Consultation Response from: KC Environmental Health (Pollution & Noise Control)
2025/90678 - 5-7 Ossett Lane, Earlsheaton, Dewsbury, WF12 8LU
Discharge of details reserved by conditions 5 (noise), 8 (boundary treatments) on previous permission 2023/90833 for Reserved matters application pursuant to outline permission 2021/91695 for erection of residential development (5 dwellings)
**Responding Date:
03 April 2025**
**Responding Officer:
Mohammed Nasim**
**Responding Ref:
WK202507875**
Comments
Condition 5 (Noise)

**Figure 1: Noise Measurement Locations**

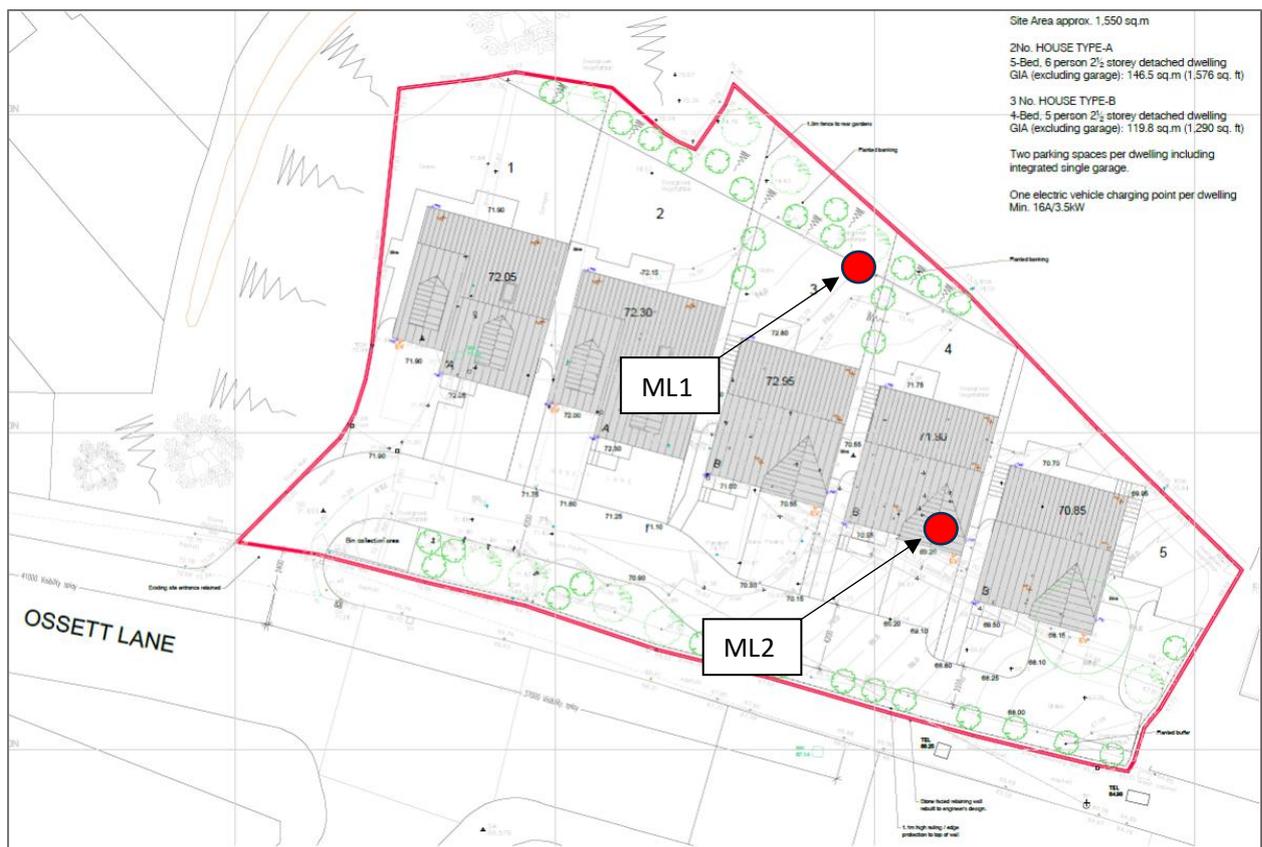
A noise survey was undertaken over a 24hr period on Thursday the 13th of February 2025 from two measurement locations as shown in Figure 1. A summary of the findings are given in tables 3 and 4 which shows that the development will meet with the requirements of BS8233 for both internal and external areas.

The submitted report is accepted.

The submitted information is accepted and we recommend this condition can be discharged.
